Memorandum

To: Kittitas County Public Works
From: Jeff Johnson, P.E.
Date: June 6, 2013
Re: Black Horse Subdivision – Flood Risk Review

Watershed Science & Engineering (WSE) was asked by the Kittitas County Department of Public Works to provide an independent general review of potential flood risks that may impact the proposed Black Horse at Whiskey Creek residential subdivision development. The subdivision is located northwest of the City of Ellensburg on an undeveloped 80 acre parcel that is bordered by three county roads and an undeveloped parcel to the west (Figure 1).

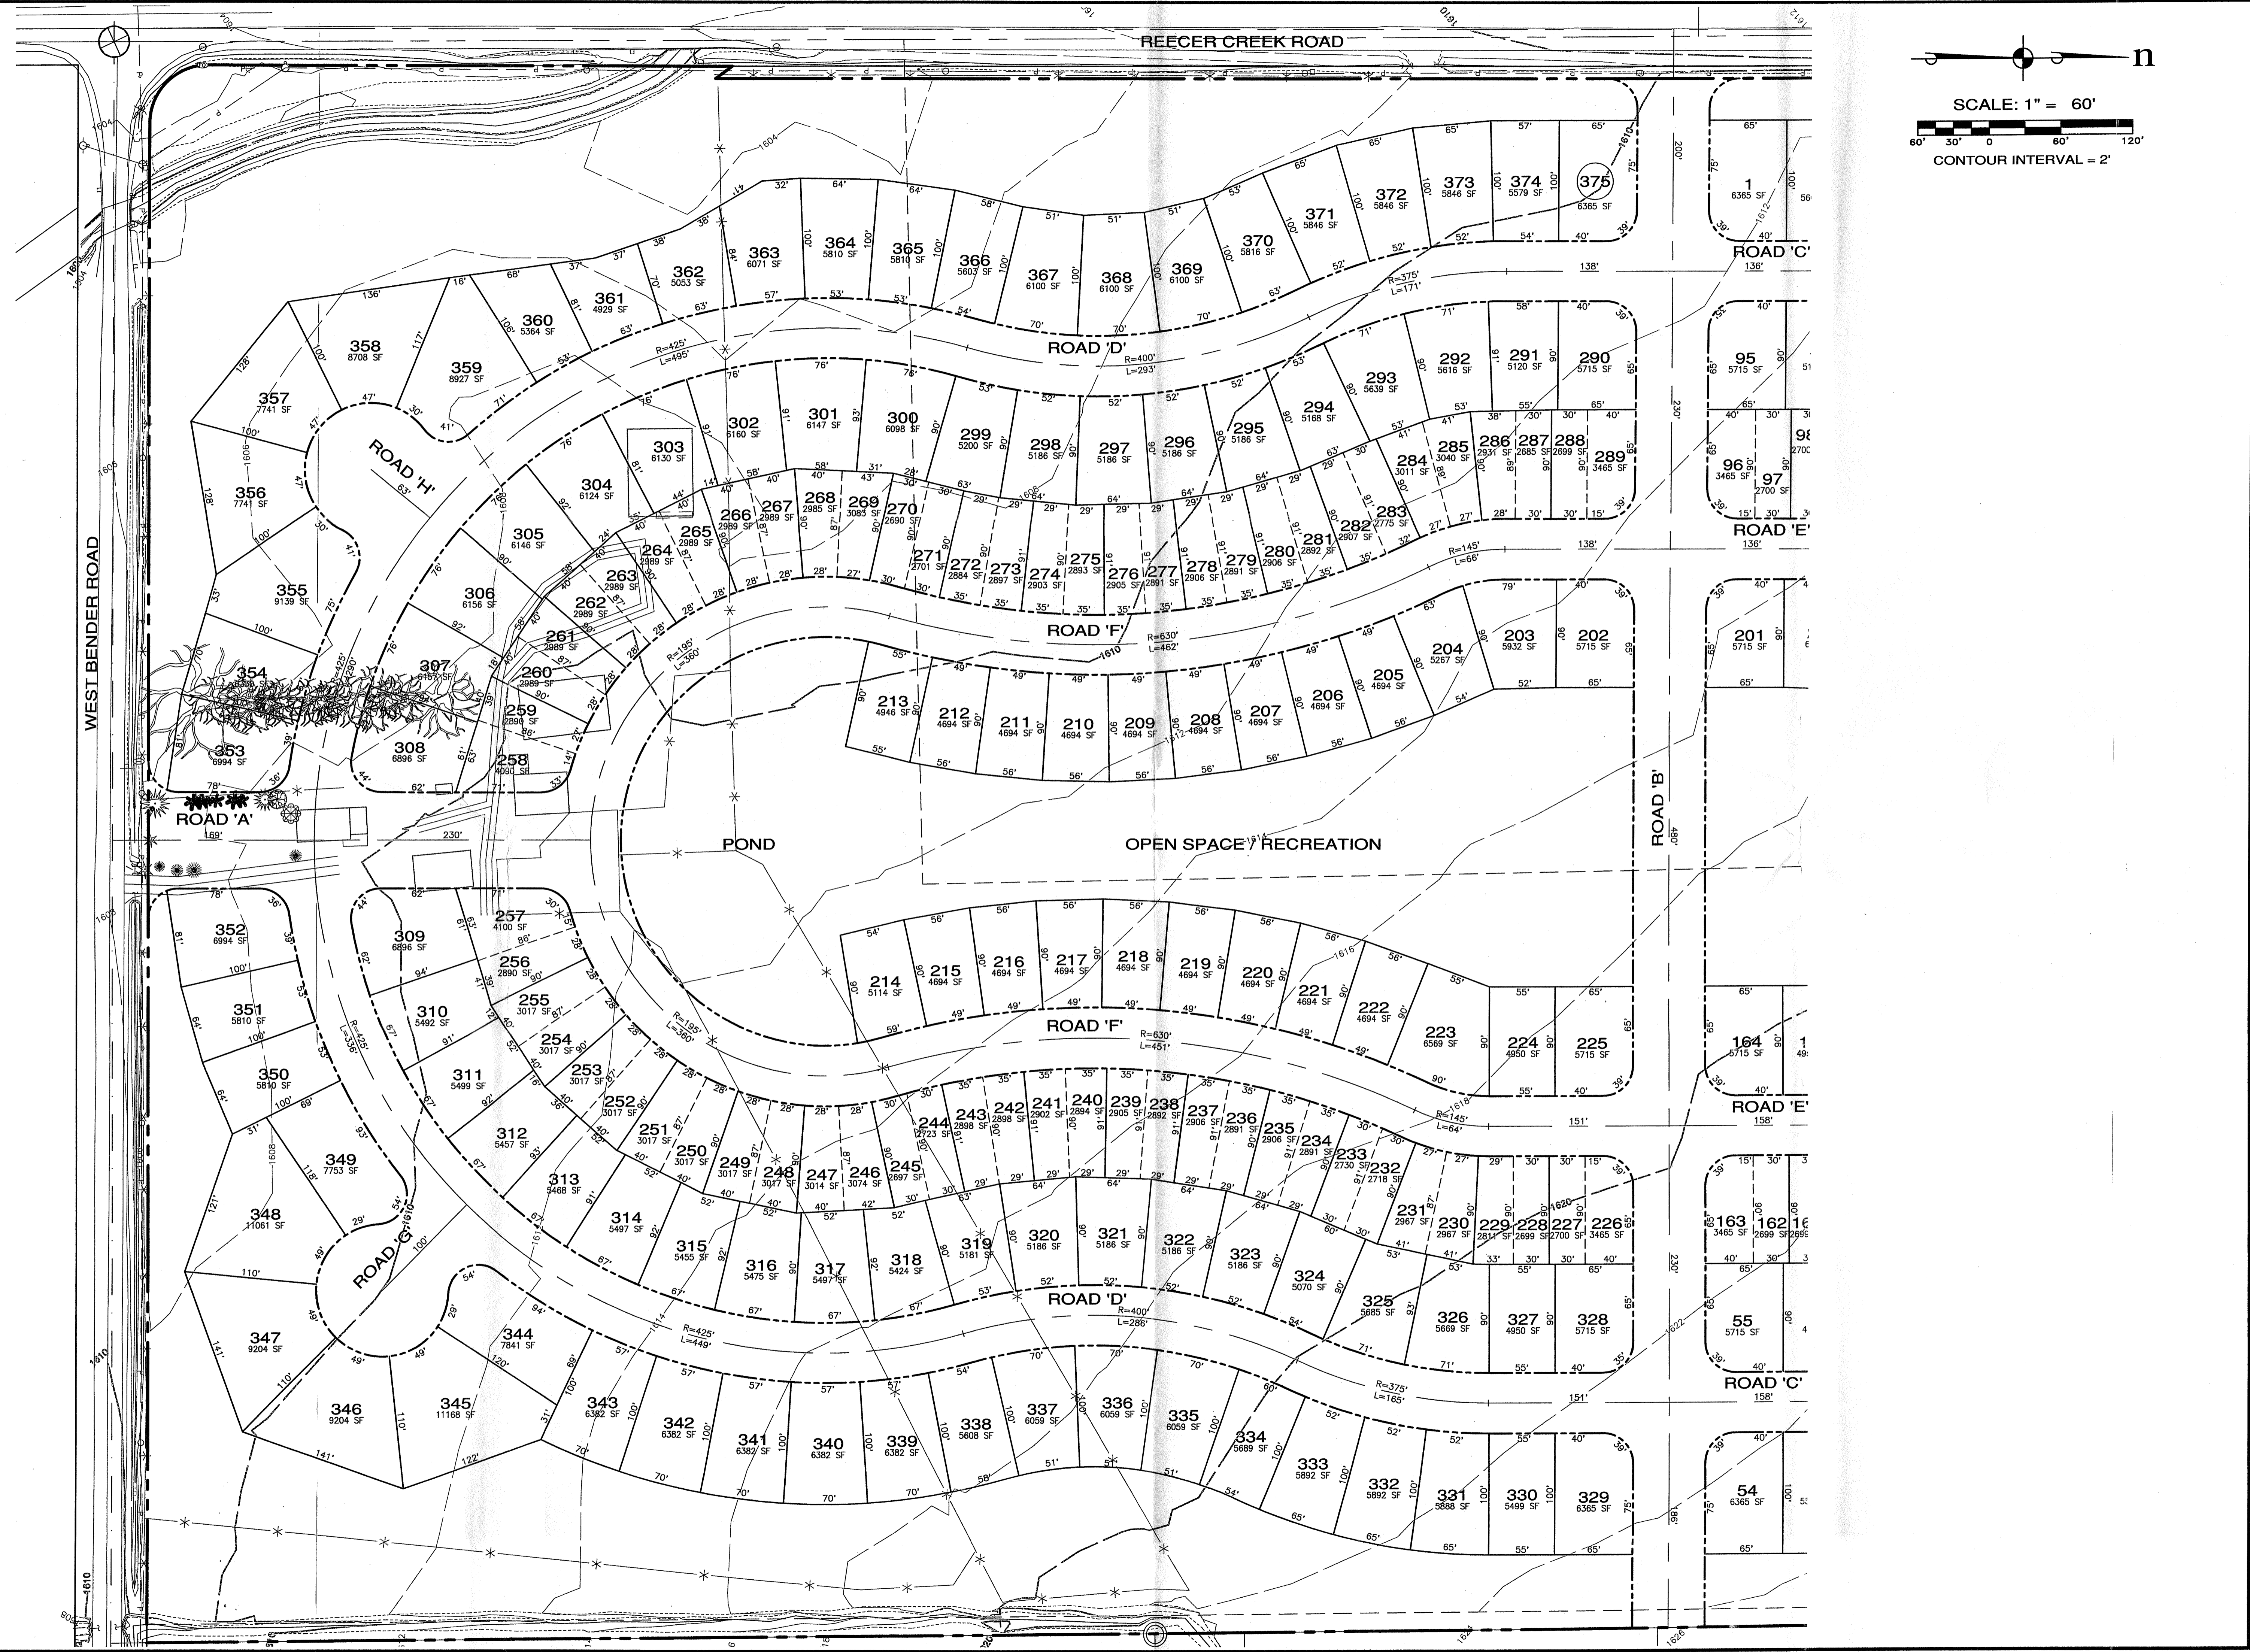
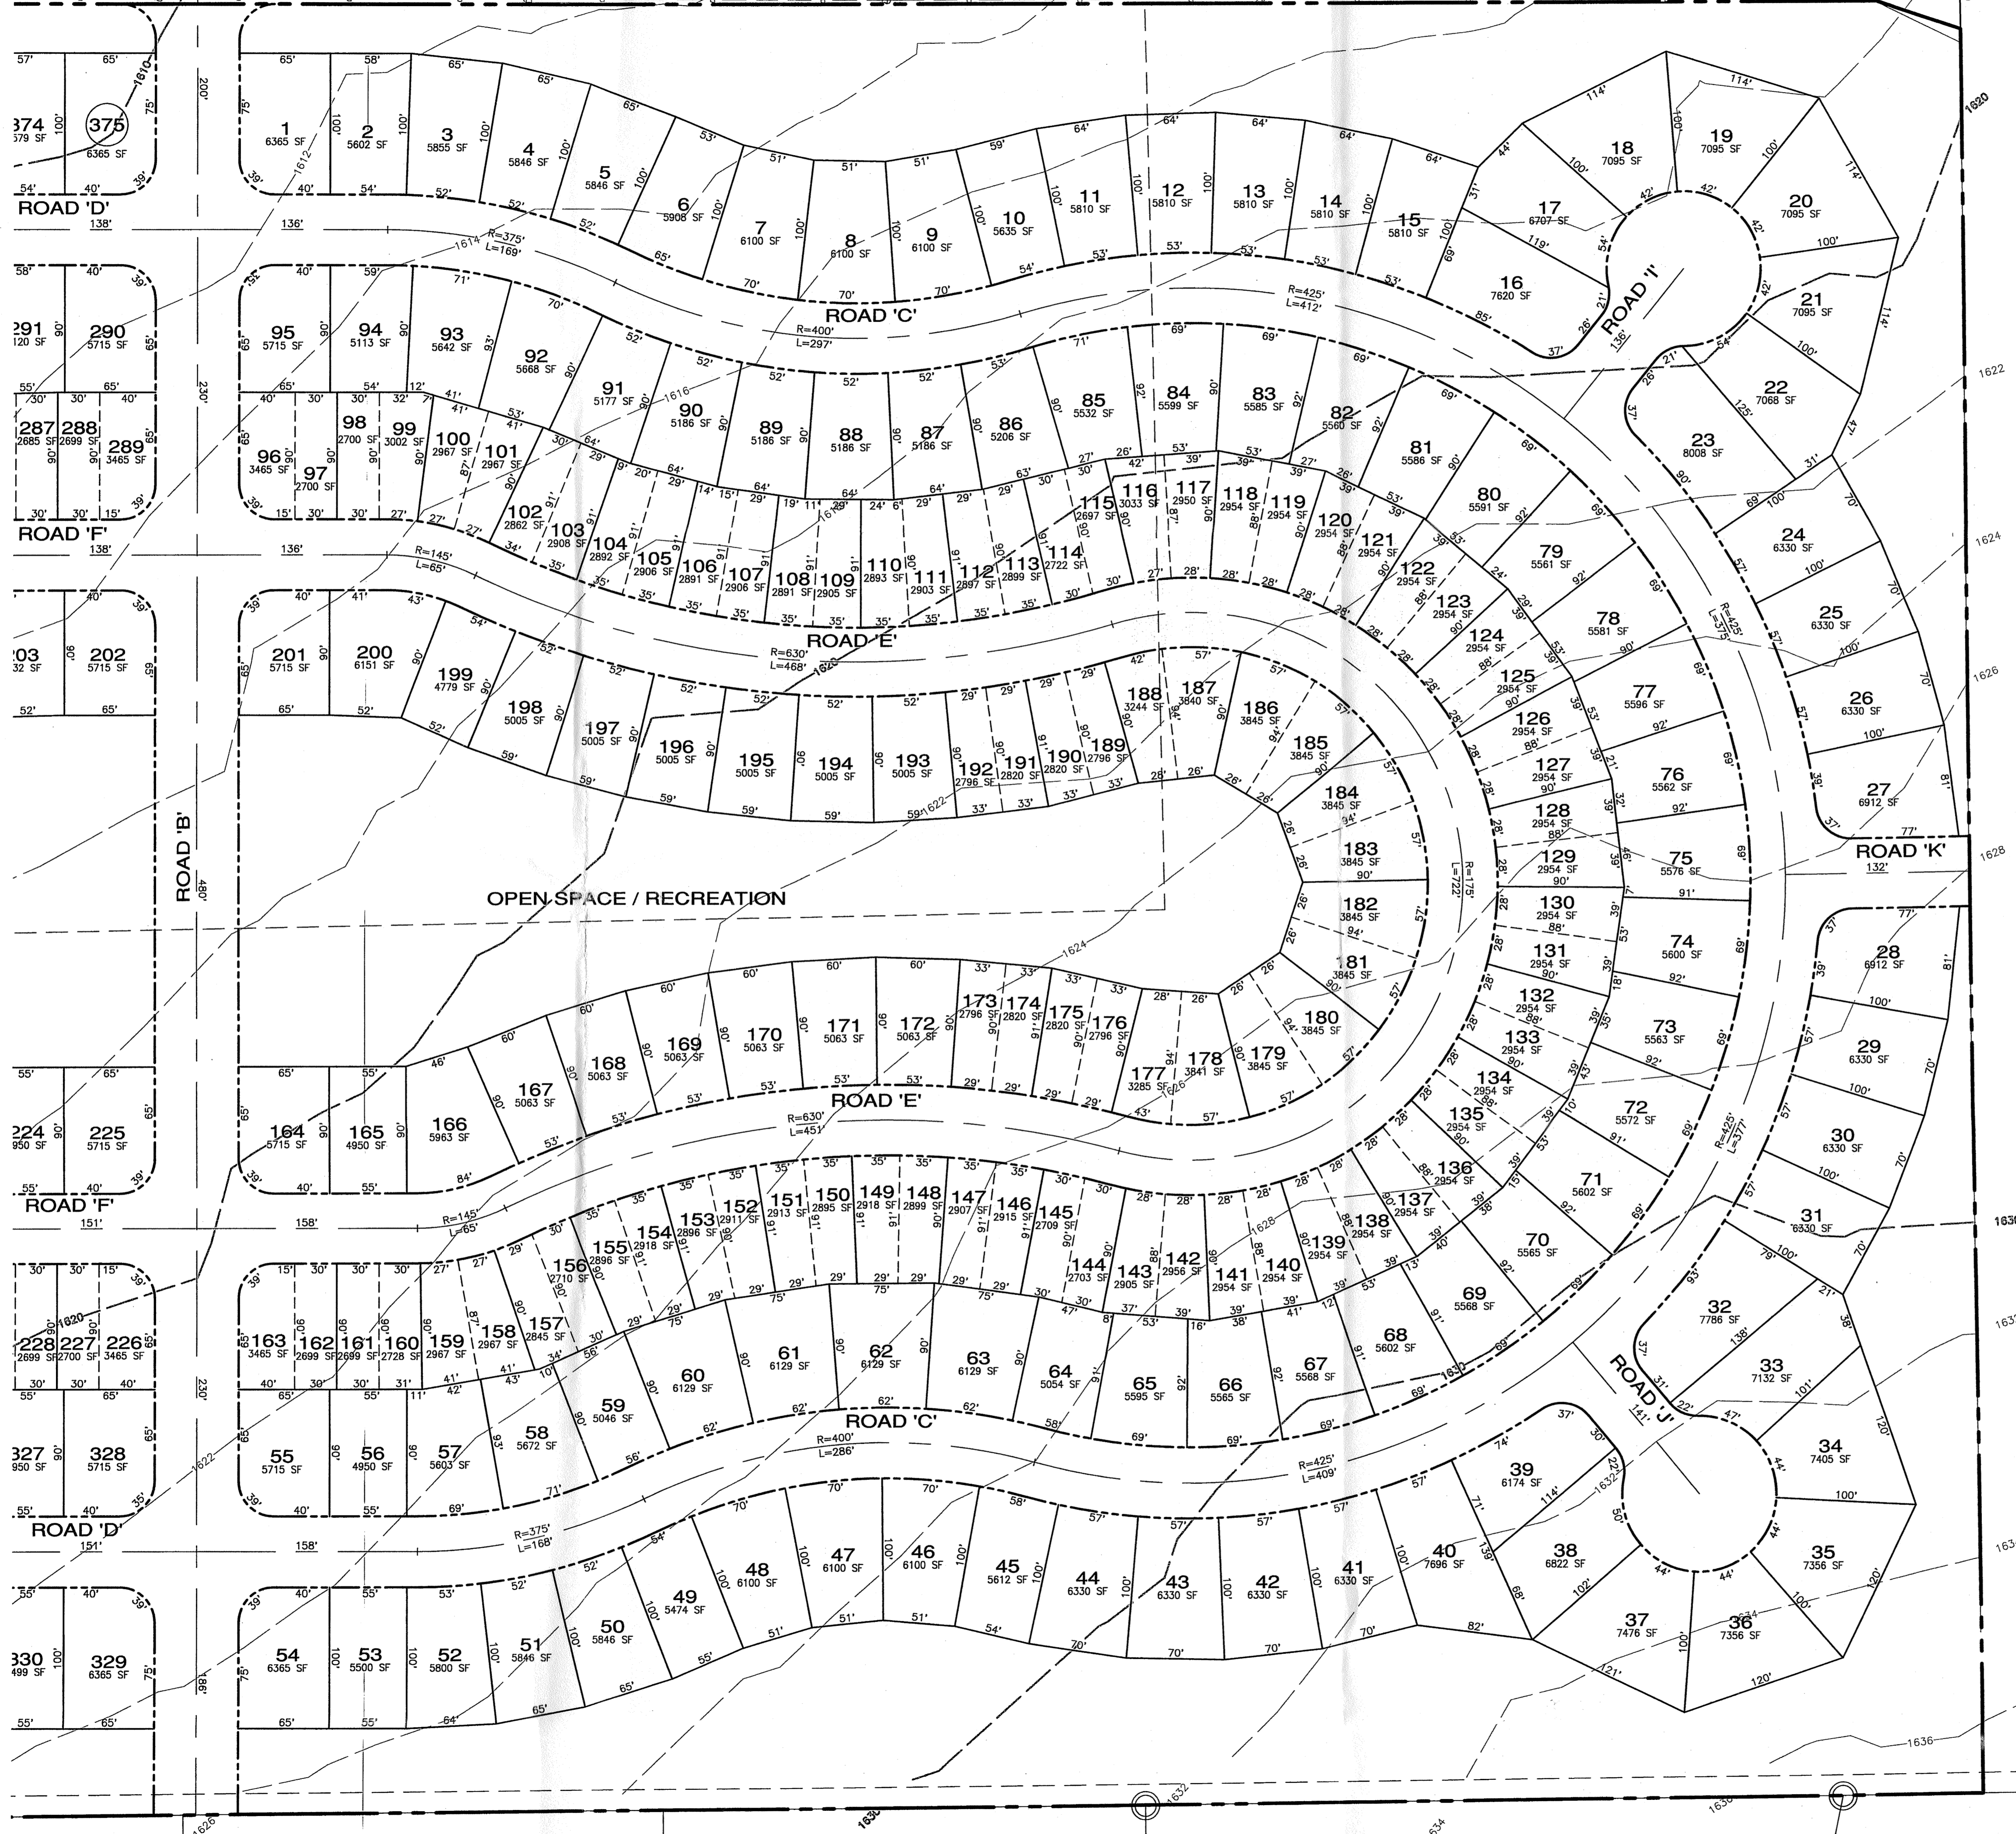
4. The focus of the flood mitigation work for the development has been on the risks Whiskey Creek poses to the southeast corner of the development. It appears however, that there may be an under-appreciated flood risk to the portion of the development that borders Reecer Creek Road. The design calls for a relatively small ditch to be constructed between Reecer Creek Road and the subdivision. We are concerned that the ditch may be too small to convey the volume of water that may enter the area during a major flood. We are also concerned that there does not appear to be a large culvert to carry the ditch under 29th Avenue, the entrance road into the subdivision from Reecer Creek Road. Our concern arises from examining the LiDAR hillshade image presented in Figure 2, the partial subdivision plan set, and from observations made by County staff during previous floods.

- a. As shown by the blue arrows in Figure 2, it appears that that flood water can leave Whiskey Creek just downstream from the Cascade Irrigation Canal and flow overland to the west, bypassing the Bowers Road Whiskey Creek crossing. This water will eventually be intercepted by the Bowers Road fill and directed west toward the intersection of Bowers and Reecer Creek Roads. At the intersection the water will over top both Reecer Creek Road and Bowers Road. The water that overtops Bowers Road will enter the road side ditch between the development and Reecer Creek Road. The volume of water entering the ditch could be large and may overwhelm the proposed ditch. This could result in flooding of the proposed sediment/detention ponds, 29th Avenue, low lying home lots that border Reecer Creek Road, etc.

- b. Flood waters may also originate from the Cascade Irrigation Canal. During floods, irrigation canals of this type intercept and convey flood water. During large storms, canals often do not have the capacity to convey all of the flood water and a portion of the flow overtops or breaches through the embankment that contains the canal. If this were to occur upstream from the subdivision, large quantities of water may enter the ditch along Reecer Creek Road. This may be an unlikely event, but it is a risk and therefore should be examined.

- c. According to the County, during the May 2011 flood, a large volume of water was conveyed along the subdivision side of Reecer Creek Road. To reduce flooding during the event, the County removed several gravel driveways that provided access into the Black Horse development site from Reecer Creek Road.

- d. The flood water that is conveyed along the subdivision side of Reecer Creek Road will enter the Town Ditch at the southwestern corner of the development. It is unclear how this would impact the Town Ditch and areas downstream along the ditch, or the adjacent portion of the subdivision.

Based upon the points above, it is our opinion that the flood risk along Reecer Creek Road has not been adequately evaluated. We recommend that a thorough investigation of flood risk be undertaken to determine if design revisions are needed to provide adequate flood conveyance facilities along the subdivision side of Reecer Creek Road. This investigation will need to include a thorough field inspection of potential overflow routes from Whiskey Creek and an assessment of the risk posed by the irrigation canal.
